27th August 2020

Application No: BE/52/20/HH
Site Address: 3 Berghestede Road Bersted PO22 9QR
Description of works: Loft conversion and ground floor side extension.

Thank you for your internet representation made on 3rd August 2020 which has been recorded as an objection with the comments as follows:

Proposed Side Extension & Loft Conversion	
Plans and Elevations	Planning
Date	June 2020
Scale	1:50

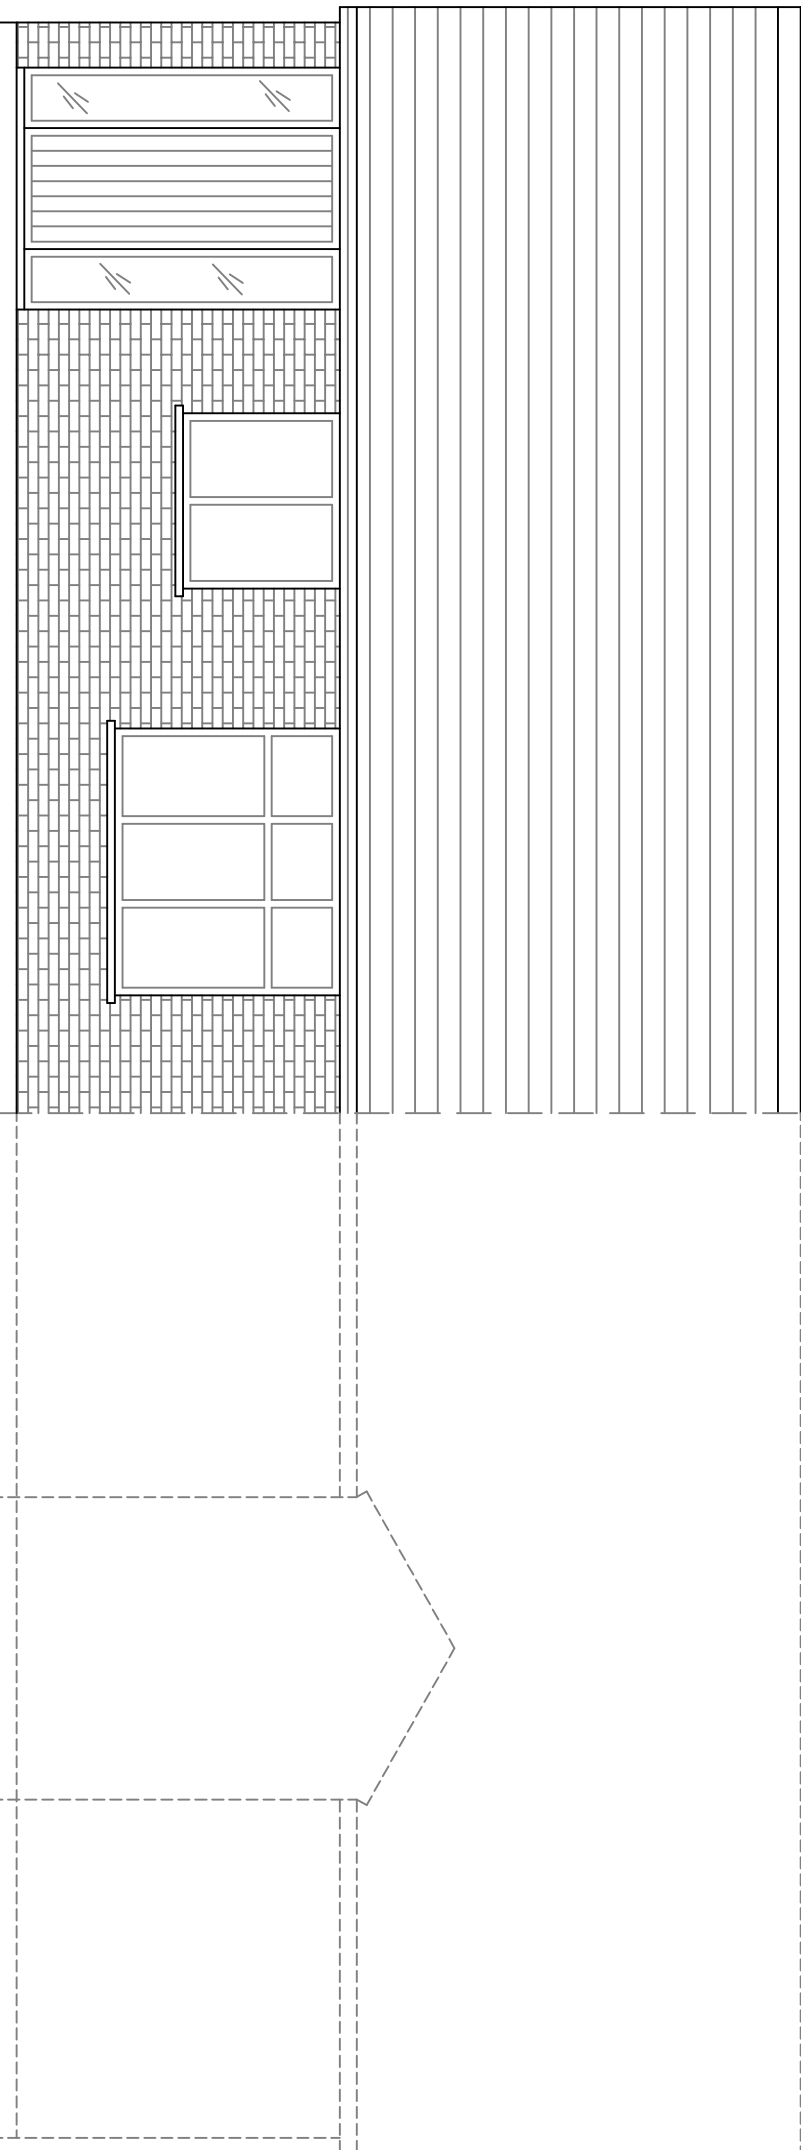
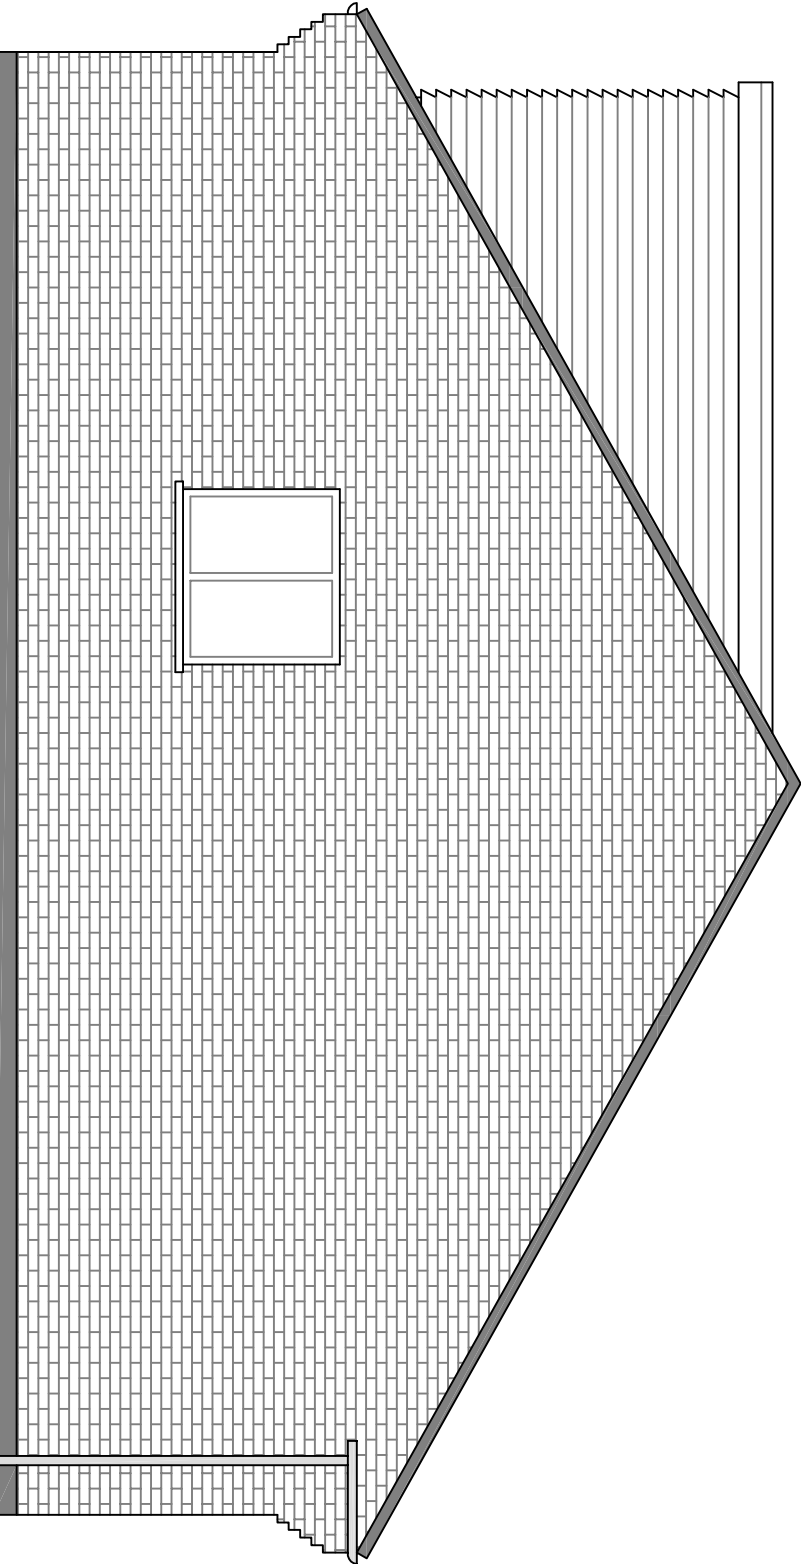
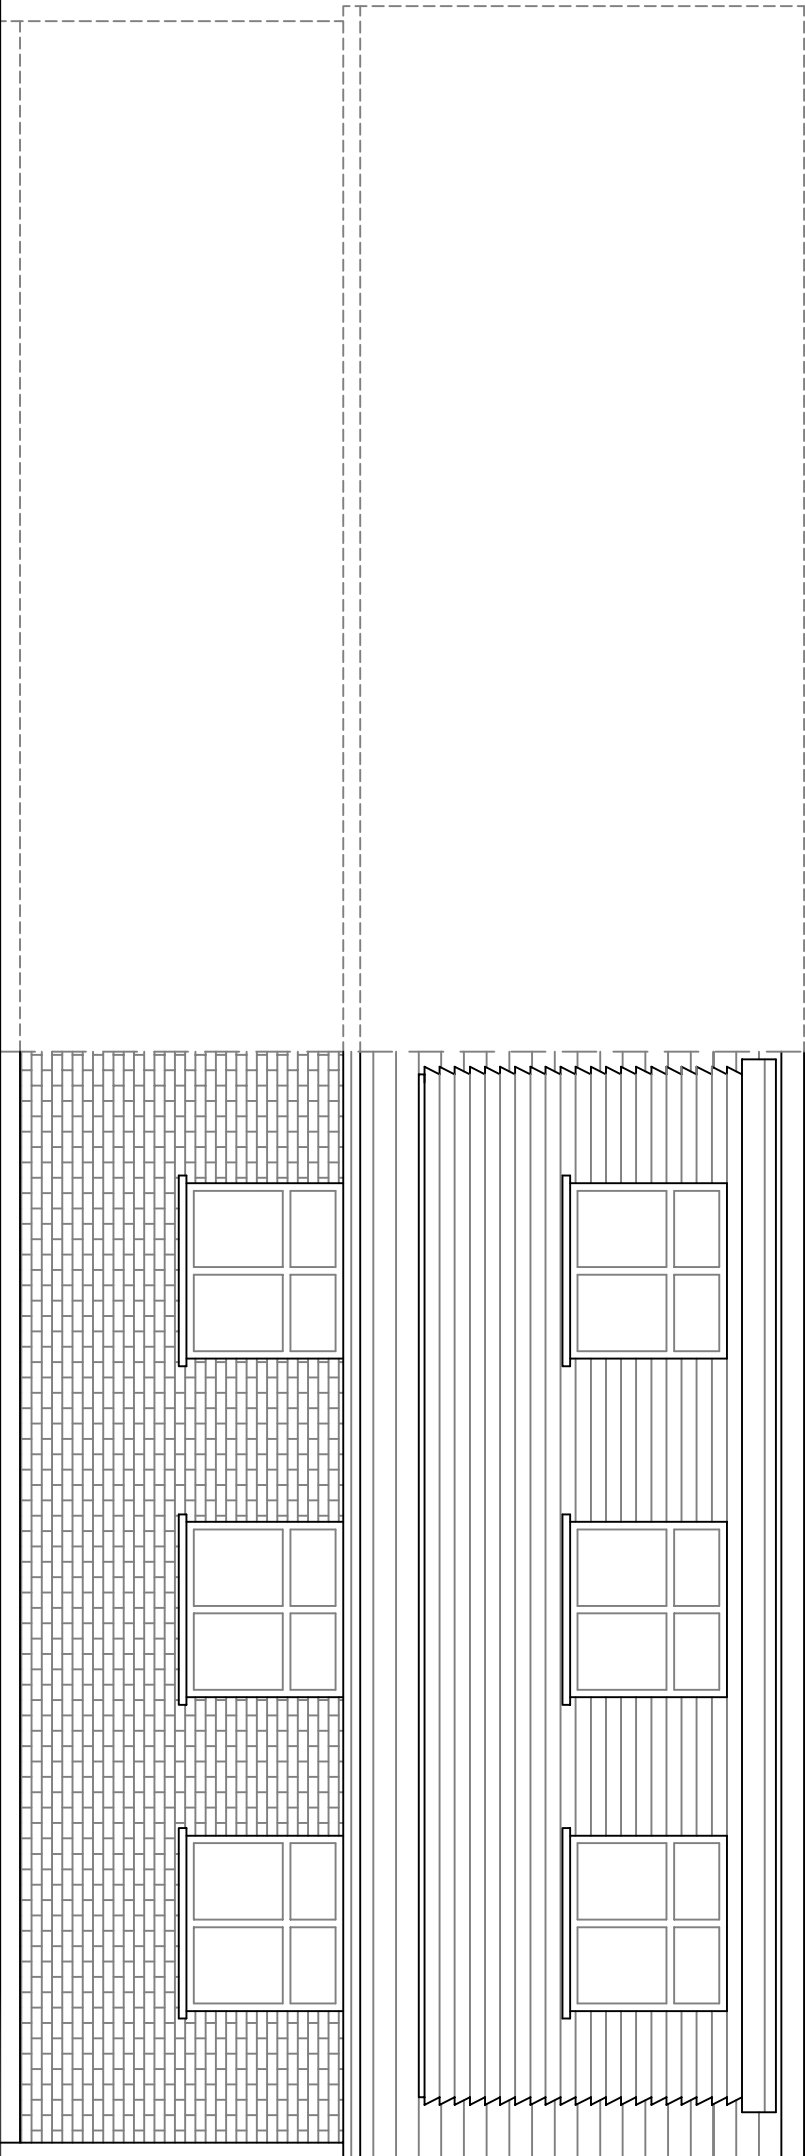
The proposal incorporates 3 windows facing the rear of 72 Ravens Way, a house I have owned for fourteen years.

This will severely effect the privacy of the property. The rear of this property has never been overlooked which was what made the property appealing to us and I would like it to stay that way.

It has a lovely large rear garden the privacy of which which would be lost once the upstairs windows are in place, a detrimental effect to my property.
